**LIBERTY TREE ACADEMY**  
 TOWN OF PEYTON, EL PASO COUNTY  
 CONSTRUCTION DOCUMENTS

**LANDSCAPE PLAN**

# Markup Summary

PLEASE REFER TO SHEET LS02 FOR PROJECT DATA, PLANT LEGEND, AND LANDSCAPE NOTES

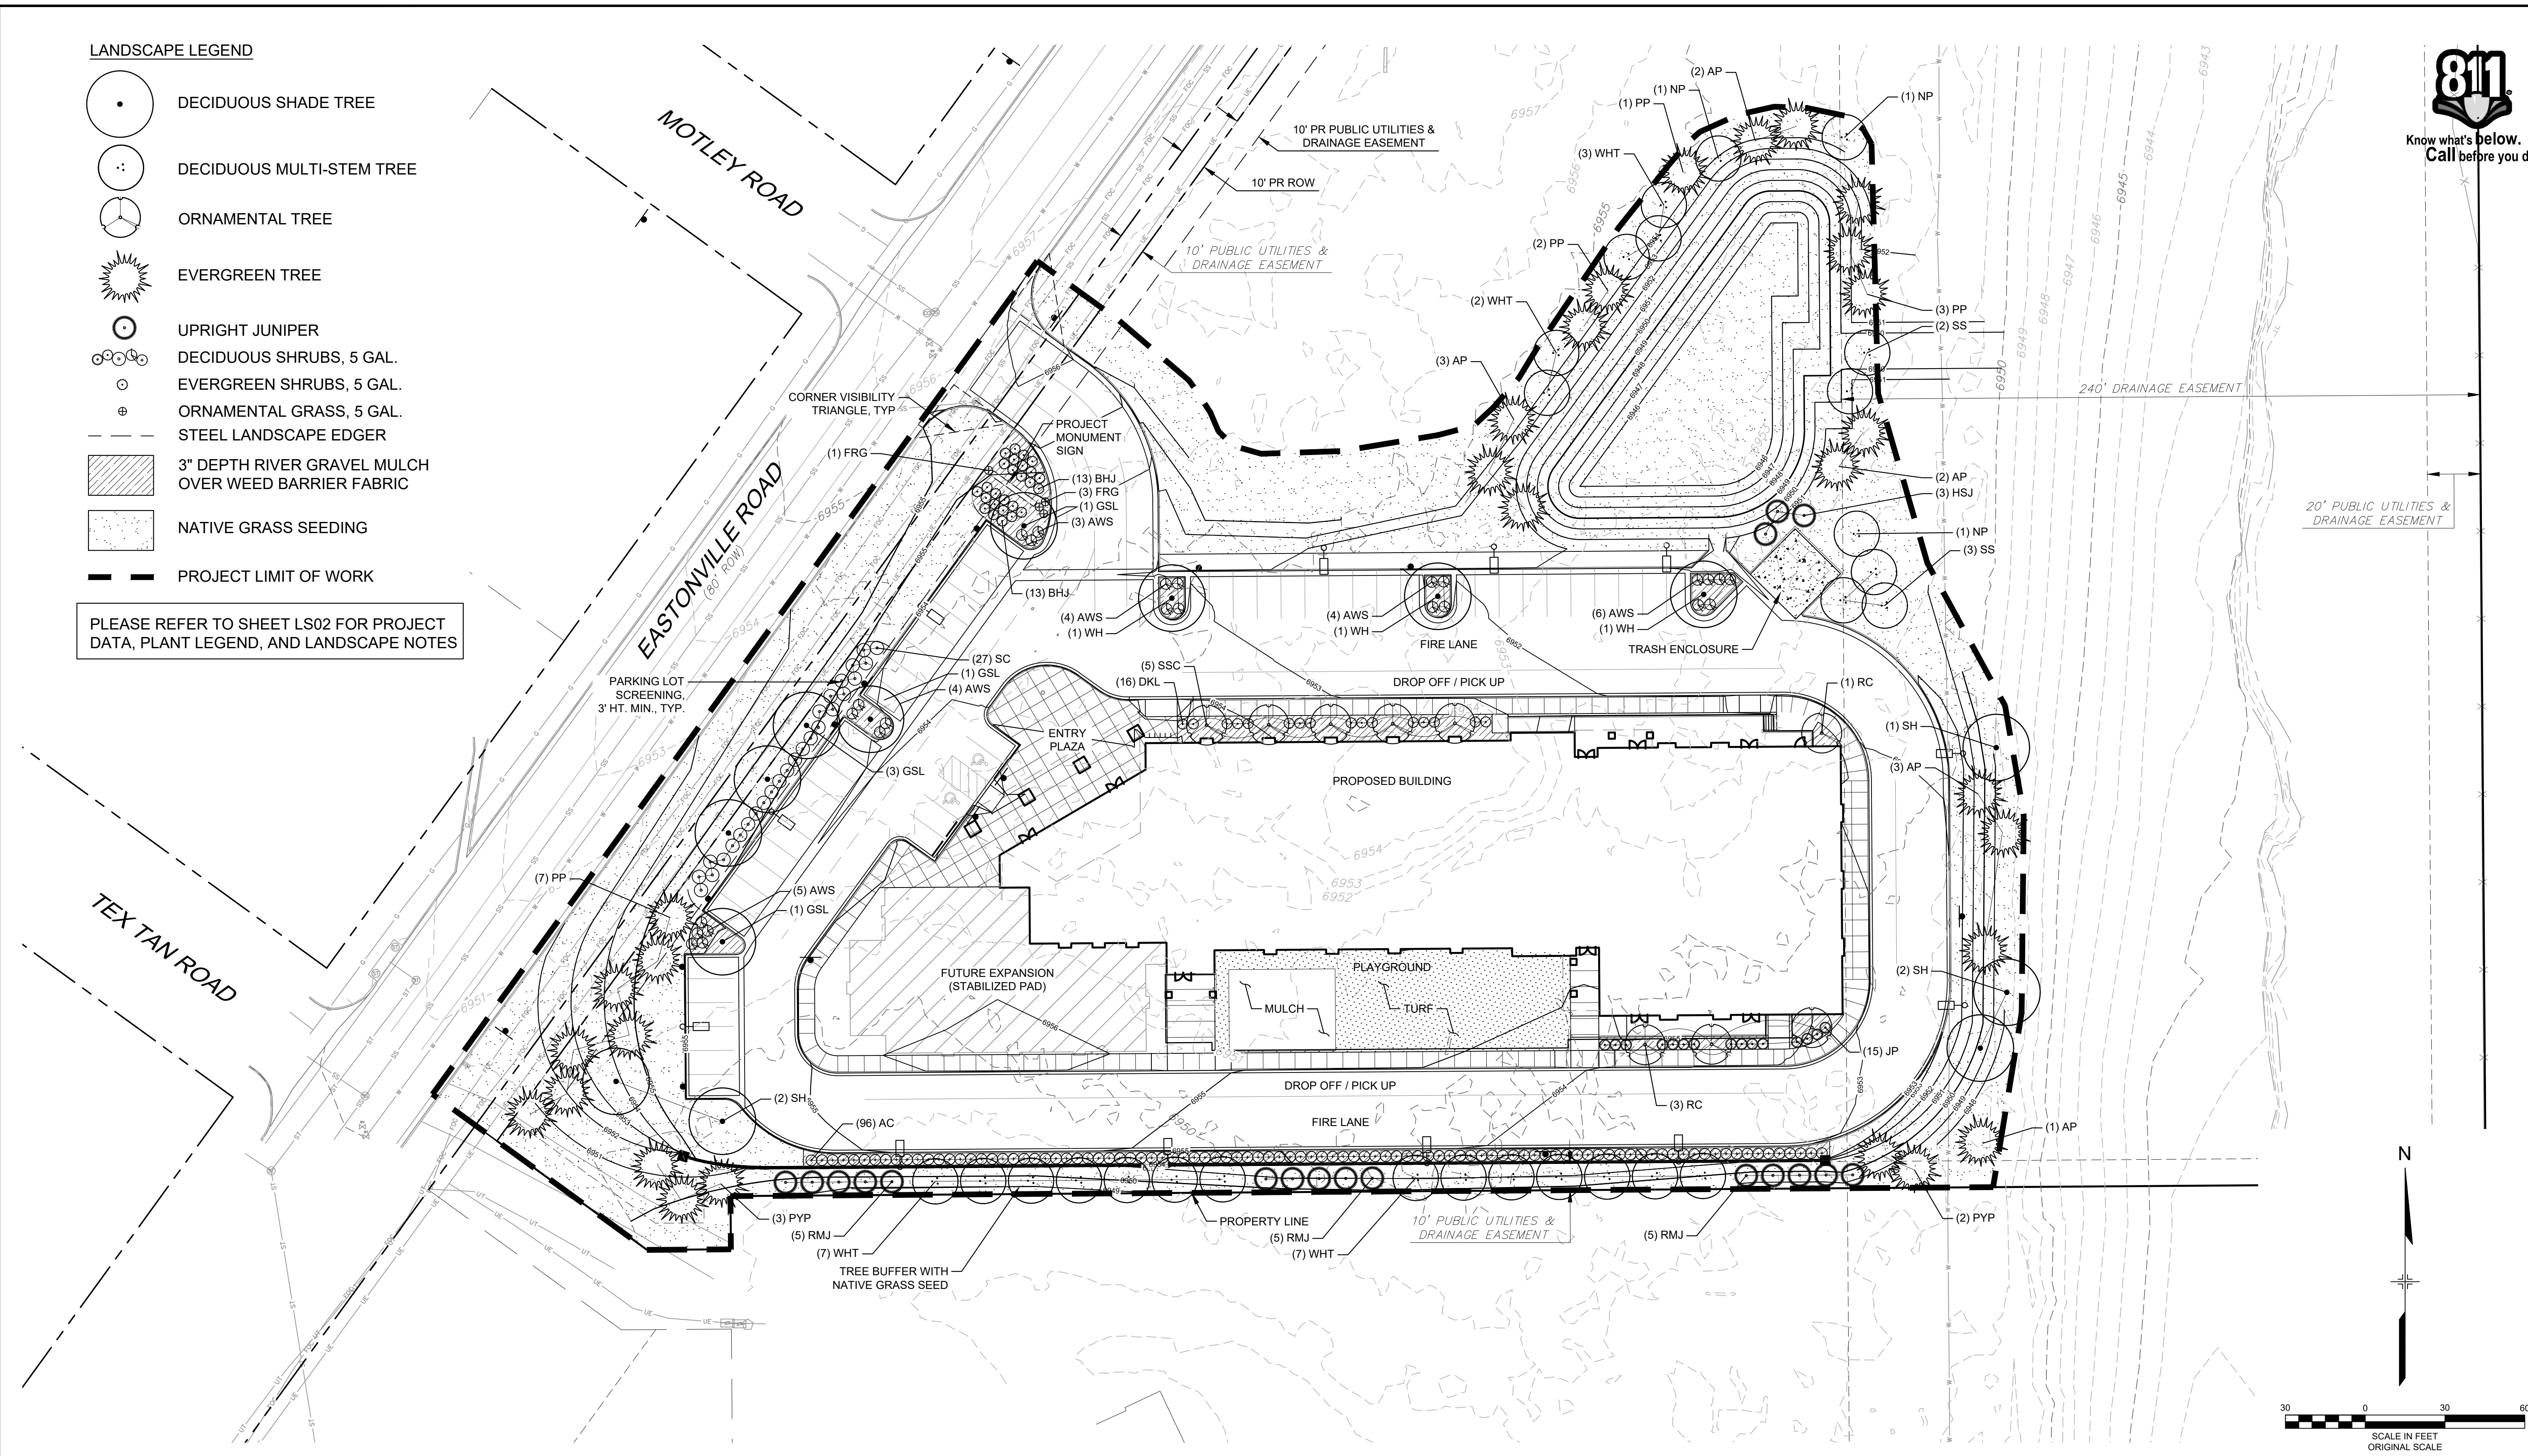
Ensure that MVEA and WHMD will allow trees where proposed.
